Your Ref: OWPC18946
Our Ref: WA/49/18/PL 02-05-2018
Please ask for:
Andrew Wood

Demolition & erection of 1 No. dwelling.
The White Cottage West Walberton Lane Walberton

Proposed New Dwelling
at White Cottage, West Walberton Lane, Walberton
for Mr. and Mrs. A. Wickland
Drawing P11 April 2018 Scale 1:100 & 1:500 @ A3
Planning Drawing - Proposed First Floor Plan & Block Plan

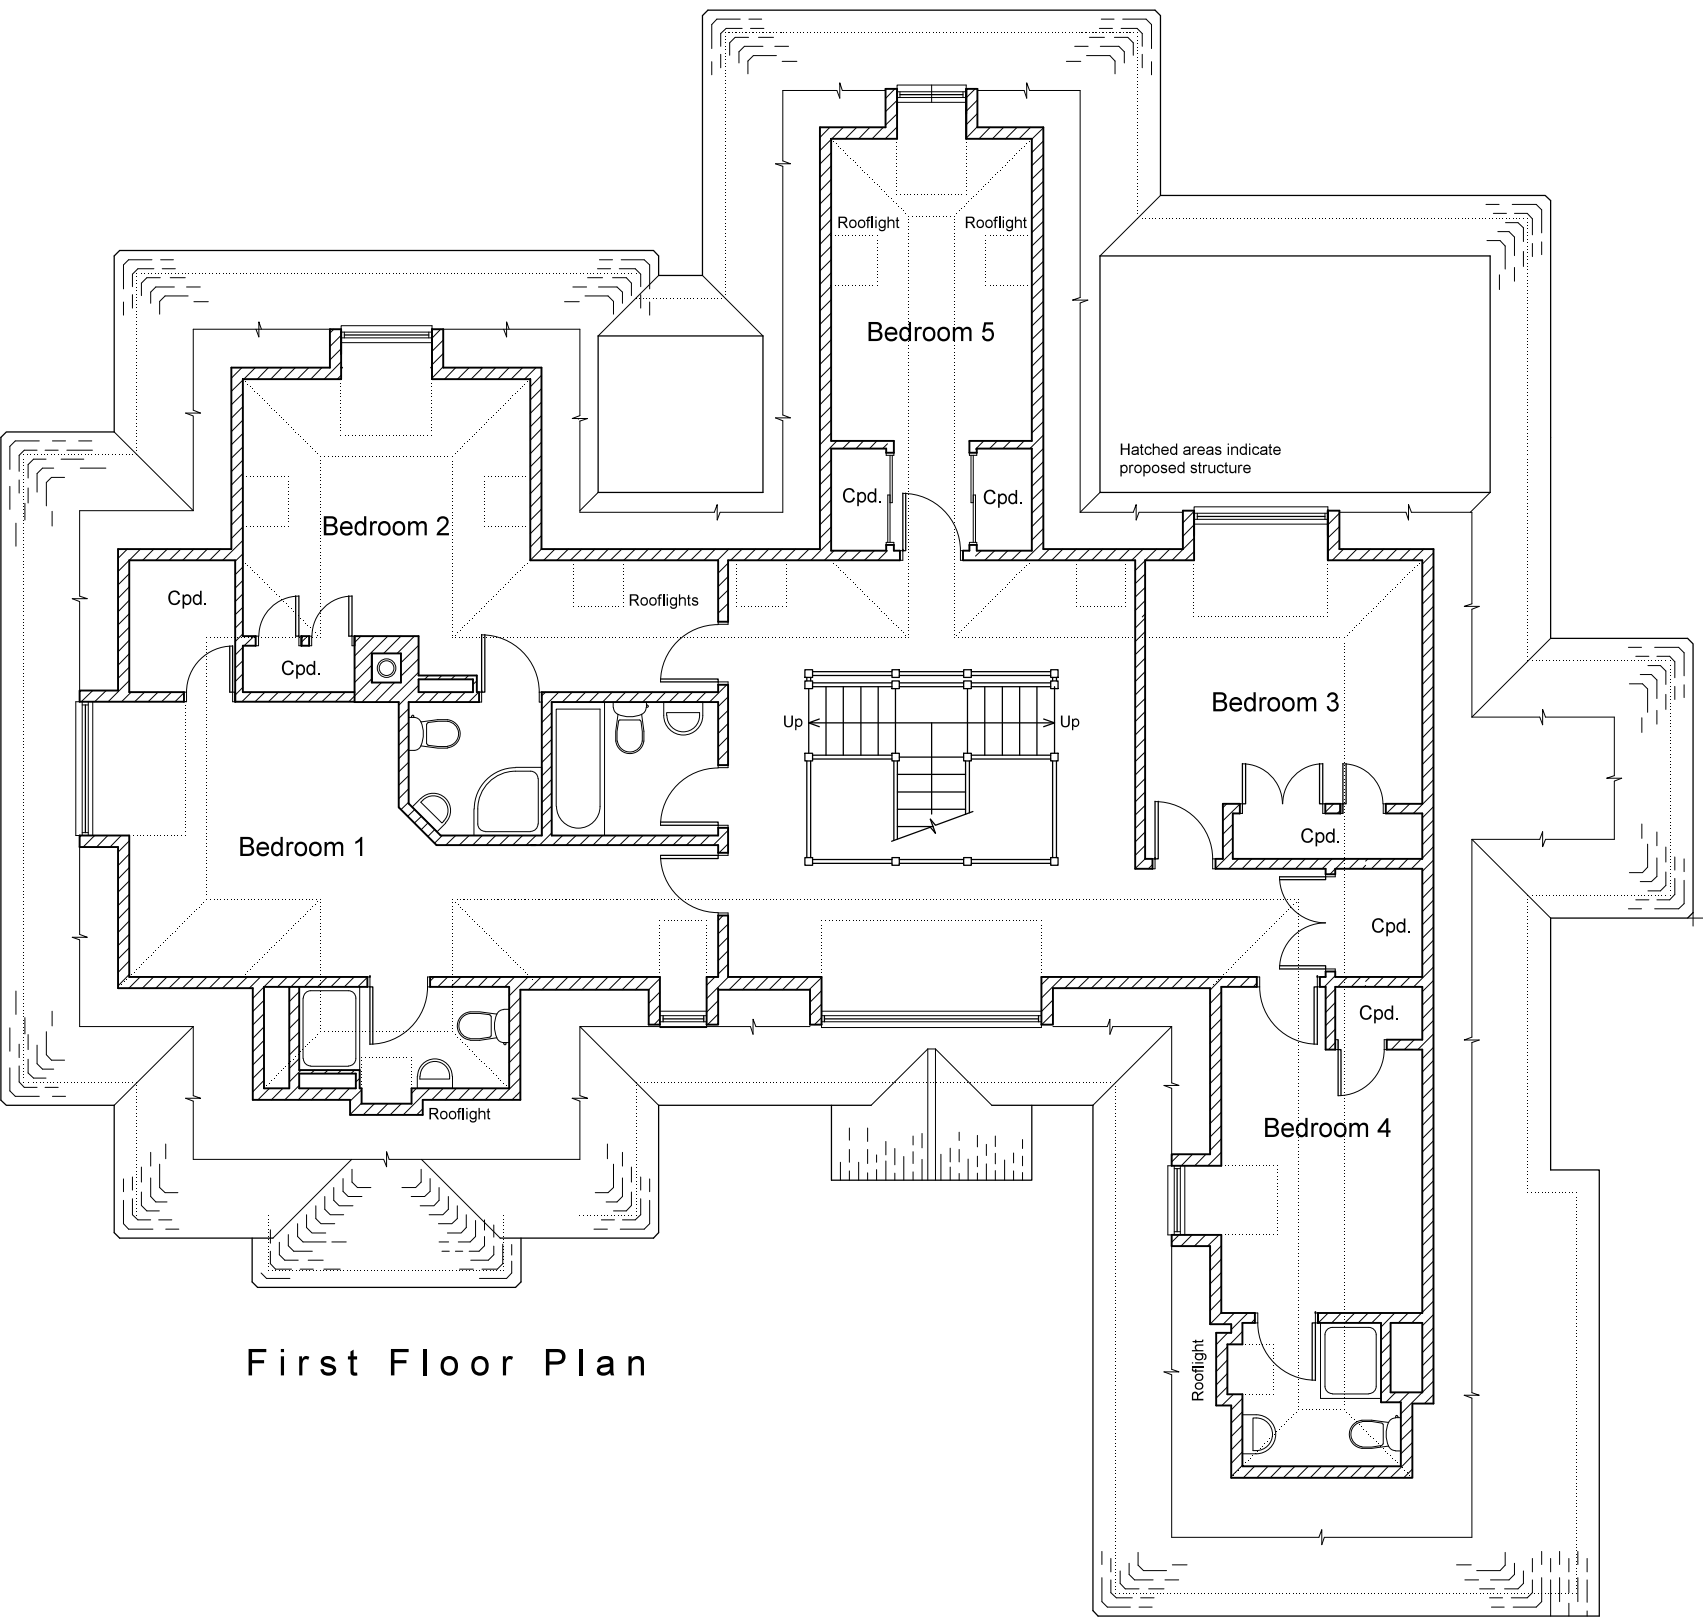
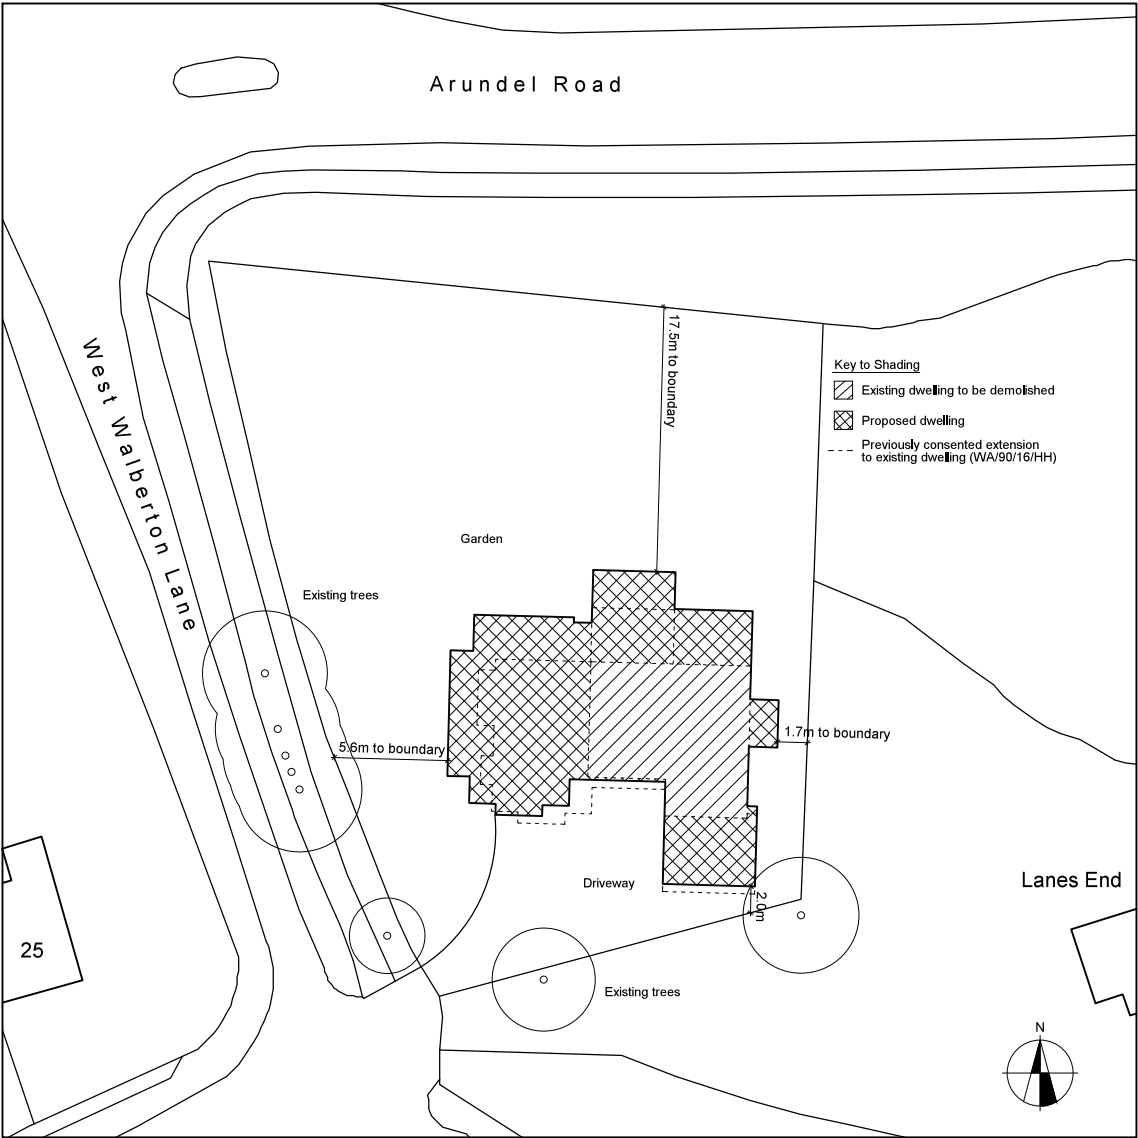
*A gravel drive should be stipulated for drainage purposes. The majority of properties in West Walberton Lane have gravel drives.
The trees and hedging should no be destroyed.
The proposed house is too large. A smaller house would be more appropriate.*
